Consultation Response from: KC Environmental Health (Pollution & Noise Control)		
2024/91199 - 140A Manchester Road, Longroyd Bridge, Huddersfield, HD1 3JA		
Demolition of existing building and erection of student accommodation with ancillary spaces, associated garden area, store and landscaping, access, and car parking		
Date Responded: 11 th June 2024	Responding Officer: RM, NH, MN	Responding Ref: WK202416328
<p>The application seeks permission for the demolition of the exiting building and the erection of student accommodation, comprising of a total of 49no. study bedrooms comprising of a mixture of self-contained studios and shared cluster flats. The proposal also includes a gym, common room, shared garden area and cycle storage facilities. We have reviewed the application and supporting information and make the following comments and recommendations.</p> <p><u>Air Quality</u></p> <p>The site of the proposed development is partly within an Air Quality Management Area, (AQMA 10) which was declared due to exceedances in NO₂ concentrations and is also next to a road of concern (A62 Manchester Road).</p> <p>An Air Quality Assessment by Redmore Environmental (ref: 7881r) (Dated: 11t

The figure below outlines the site surroundings and measurement locations:

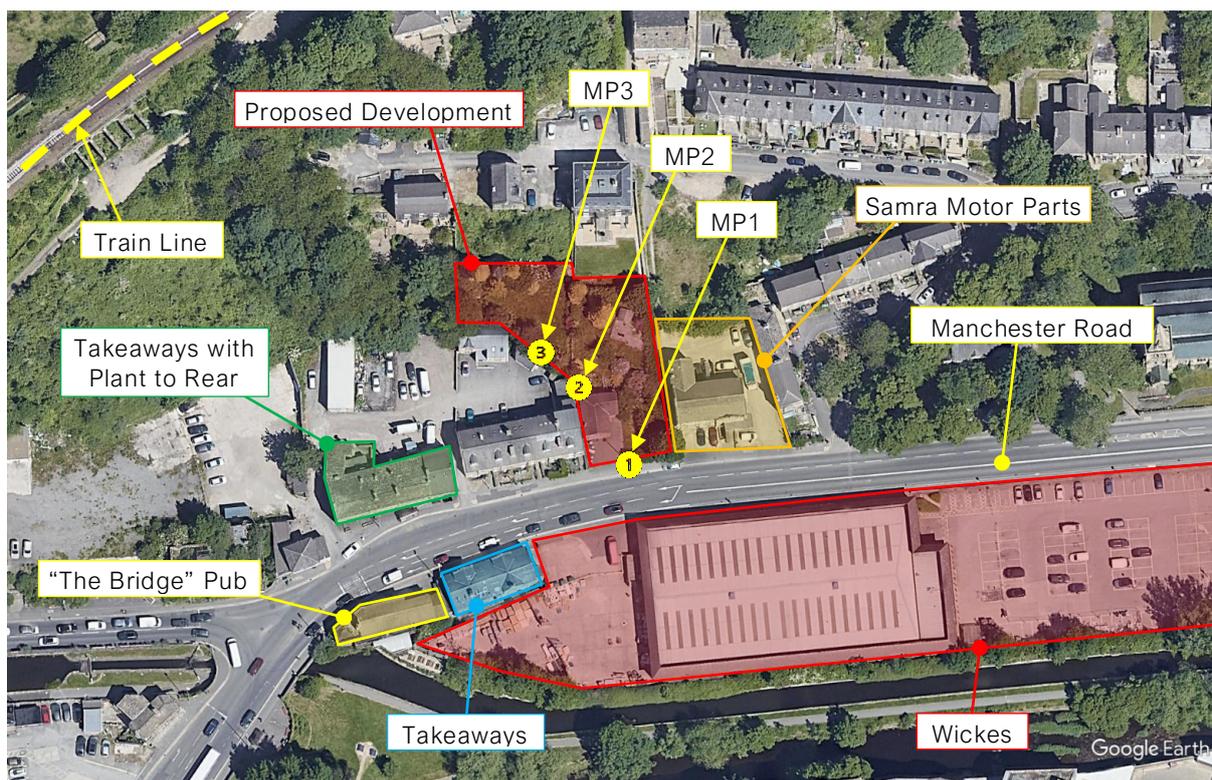
A background noise survey was undertaken between the 15th and 16th of March 2024 from 3 monitoring positions (MPs) as shown in figure 2. A summary of the findings is given in tables 2 and 3. Comment is made that the acoustic environment is deemed to be moderate in level and the noise profile is dominated by heavy road traffic noise emissions on Manchester Road with very few lulls during the site visits.

Figure 5 – L_AF_{max,1min} Sound Map

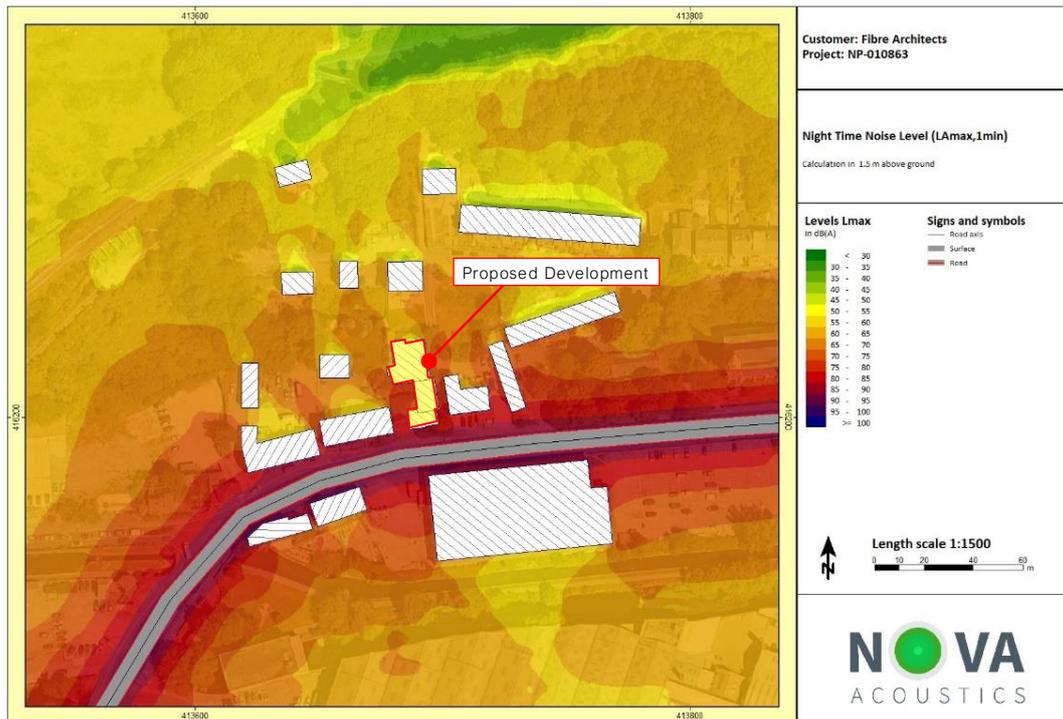
Noise modelling has been conducted for both daytime and night time as shown in figures 3-5 with predicted levels higher than the measured levels at MP3, ensuring a robust assessment and further corroborating that road traffic noise is dominant at the site. In order to meet with the requirements of BS8233, a specification for glazing and ventilation is given dependent upon the façade as shown in figure 6. This is also applicable to the room-in-roof construction as specified in para 4.3.
